WEST SUSSEX COUNTY COUNCIL CONSULTATION

TO:	Arun District Council FAO: M. Tomalova
FROM:	WSSC - Highways Authority
DATE:	4 April 2022
LOCATION:	Arun Retail Park Shripney Road Bognor Regis PO22 9NF
SUBJECT:	BE/16/22/PL External alterations to the existing building associated with the change of use from Class E Restaurant to Sui Generis (consisting of a coffee shop / restaurant selling food and drink for consumption on and off the premises), alterations to car park (including the creation of a drive-through lane, reconfiguration of cycle parking, new pedestrian crossings, and the increase in number of car parking spaces), relocation of footpath, removal of 4 x TPO trees (to be replaced), landscaping and associated works. This site is in CIL Zone 4 (Zero Rated) as other development.
DATE OF SITE VISIT:	1st April 2022
RECOMMENDATION:	Advice
S106 CONTRIBUTION TOTAL:	n/a

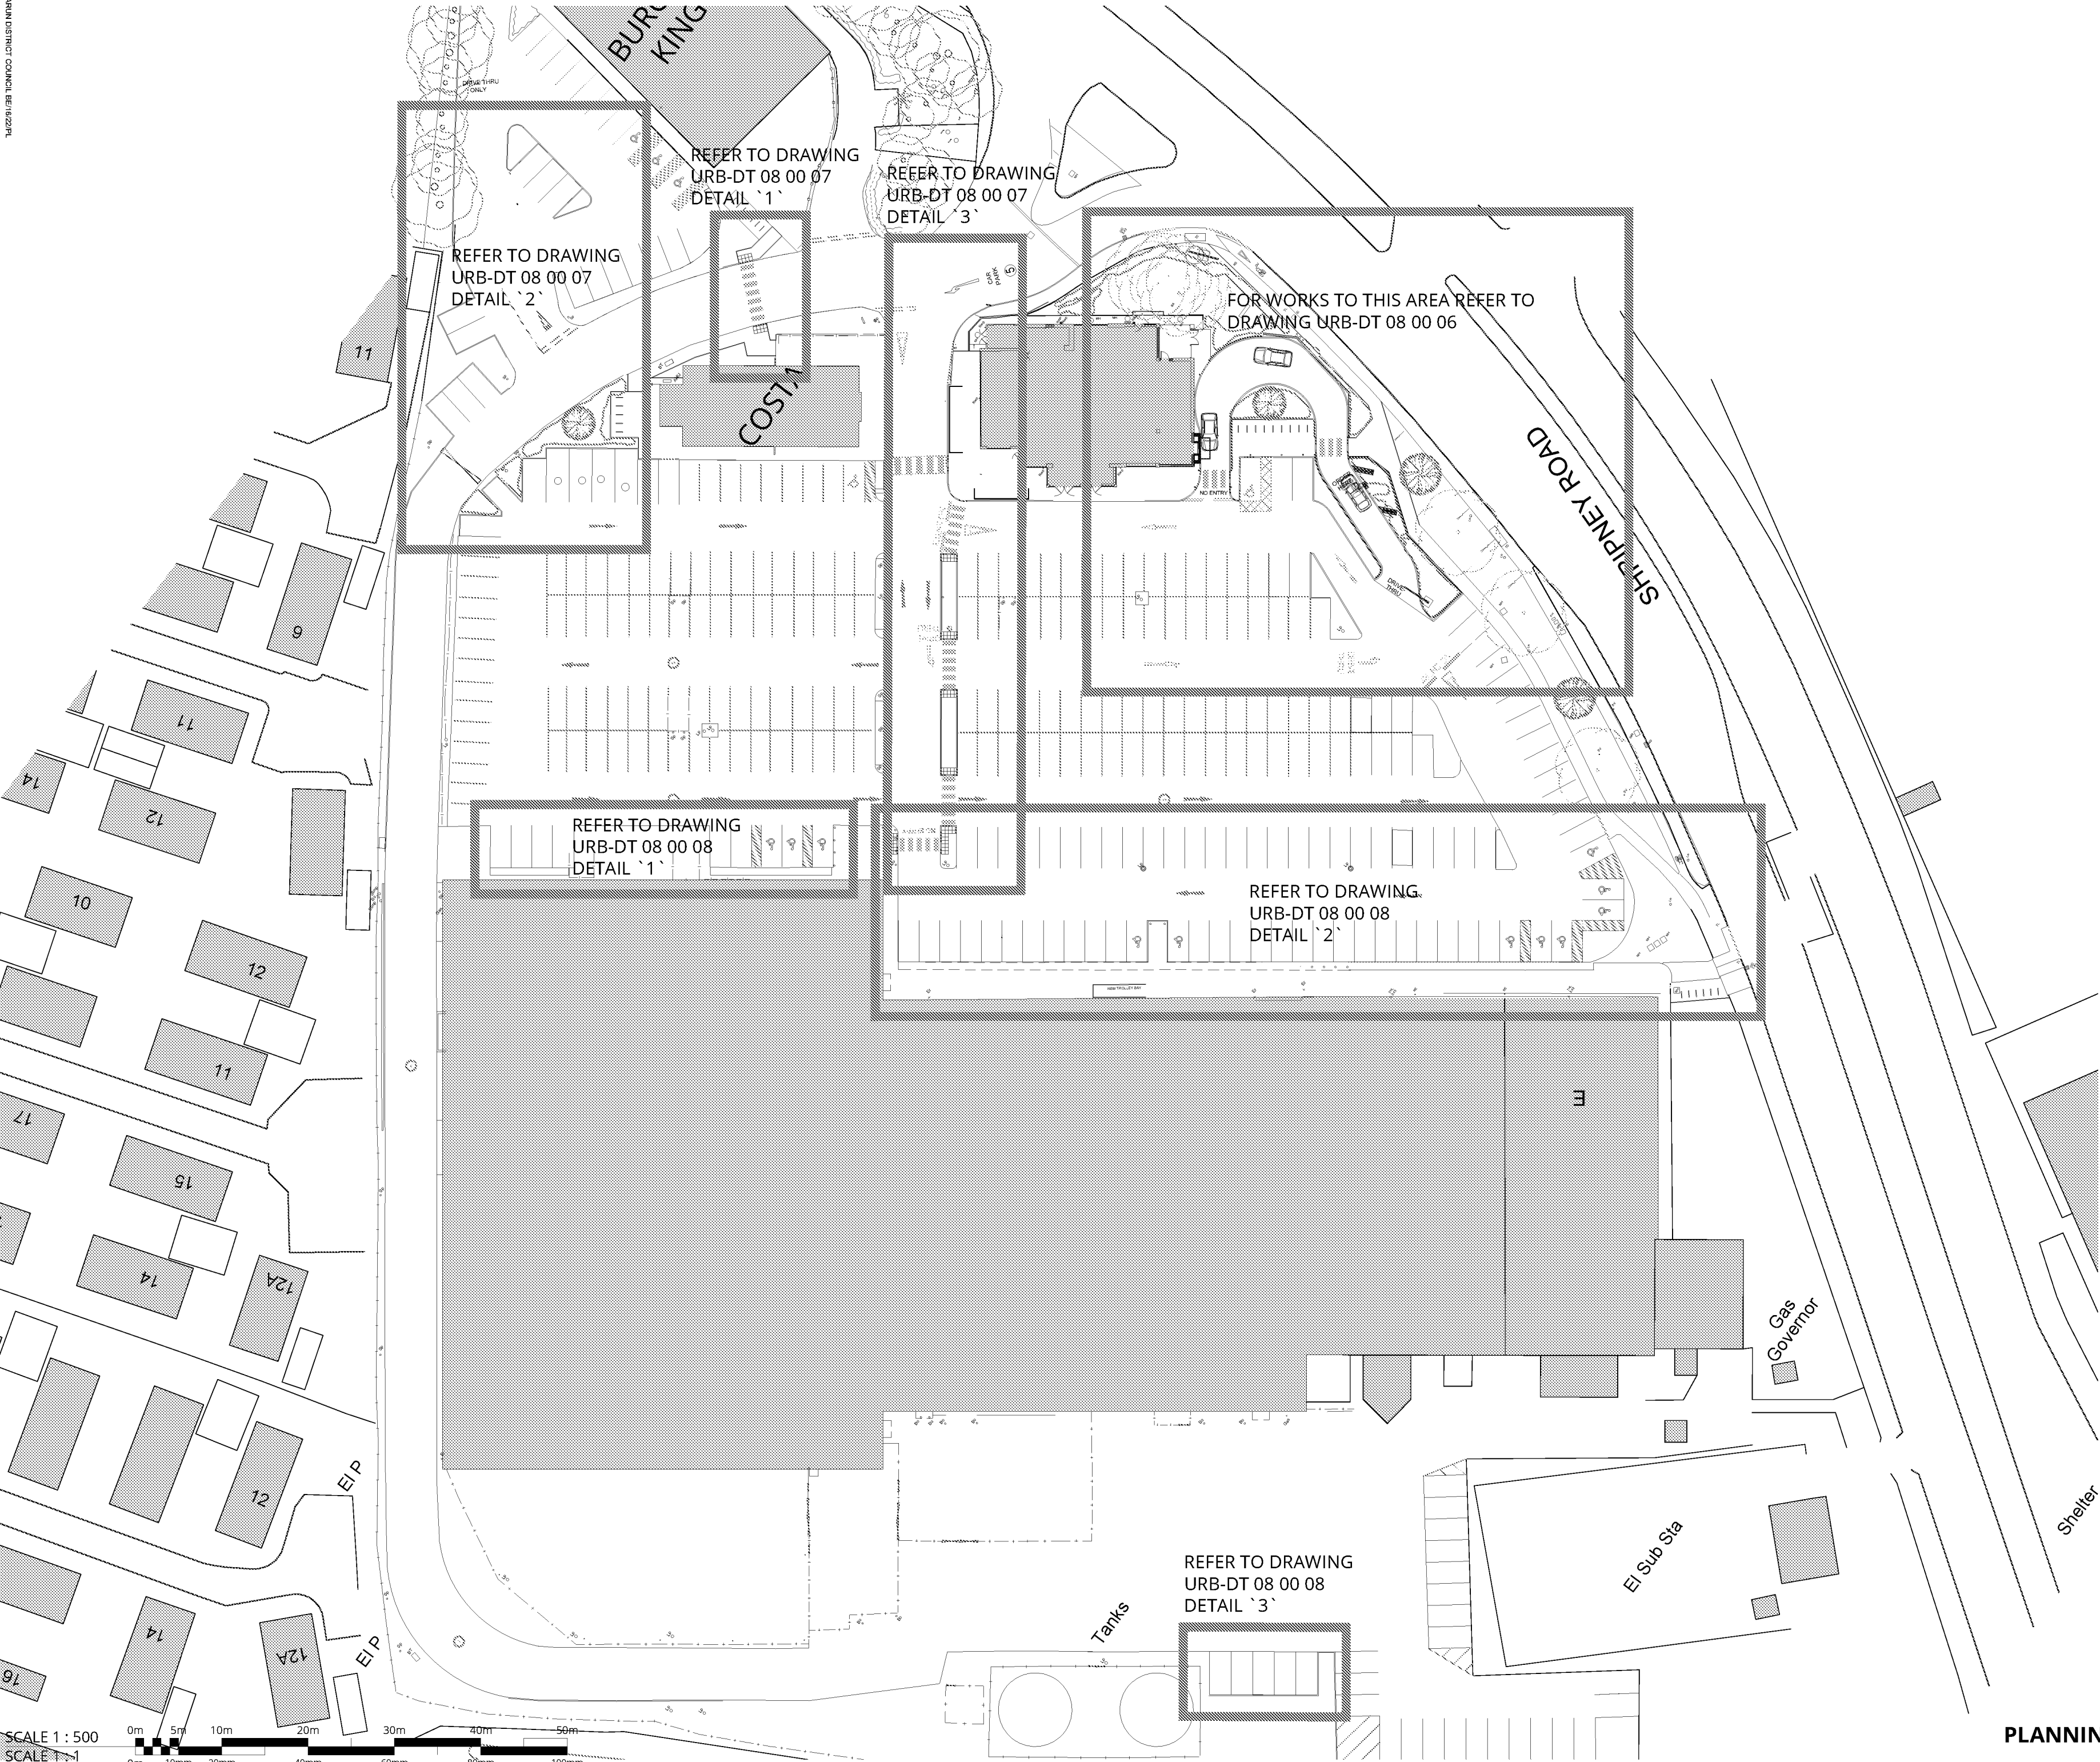
An area of existing highway verge adjacent to the A29 is required to allow for the Drive Thru facility. The plans do not appear to show an existing totem sign is currently in close proximity to where this application proposes the drive thru lane. There may be a requirement to re-site this sign to an appropriate location. The 'Stopping Up' process can be obtained in tandem with the planning application to 'Stop Up' the area of land as outlined within the TA. As part of this consultation we have made the Area Highway Manager aware of the potential application. The process should be applied for through the The Town and Country Act.

The applicant is advised that the existing public highway to be incorporated into the development must be the subject of a Stopping Up Order. This process must be successfully completed prior to any highway land being enclosed within the development. The applicant should contact the Department for Transport's National Transport Casework Team in order to commence this process:
